Our Ref C5076/25/E/7735  
12<sup>th</sup> February 2026

Ref: Consultation Response to Coal Mining Risk Assessment.

GROUND FLOOR PLAN

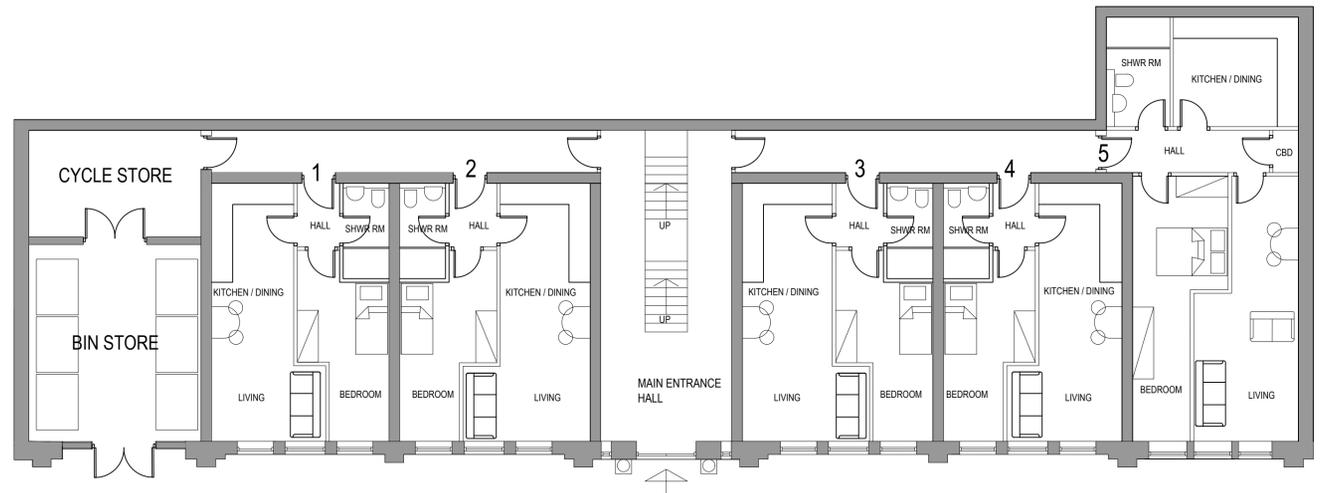
RGS have produced three plans, all of which are attached. On the first two plans, the recorded adit location is plotted, in addition to a 10m departure zone (yellow circle). The first plan shows an overlay of the proposed development. As can be seen there is a potential for the adit to be present within either Plot 18 or 19. The second plan shows the satellite imagery; it should be noted that the redline boundary is indicative. The third plan reveals the area within the planning boundary that will require investigation.

It is of note that the CMRA recommended a grid of dynamic probes. However, it is suggested that this be revised to a grid of shallow rotary boreholes as dynamic probes could refuse on obstructions. Indeed, in addition to the adit, there may be a potential for shallow mine workings also, albeit again this is considered to be restricted to the area of Plots 18 and 19. Nevertheless, rotary boreholes would be a more suitable investigative method.
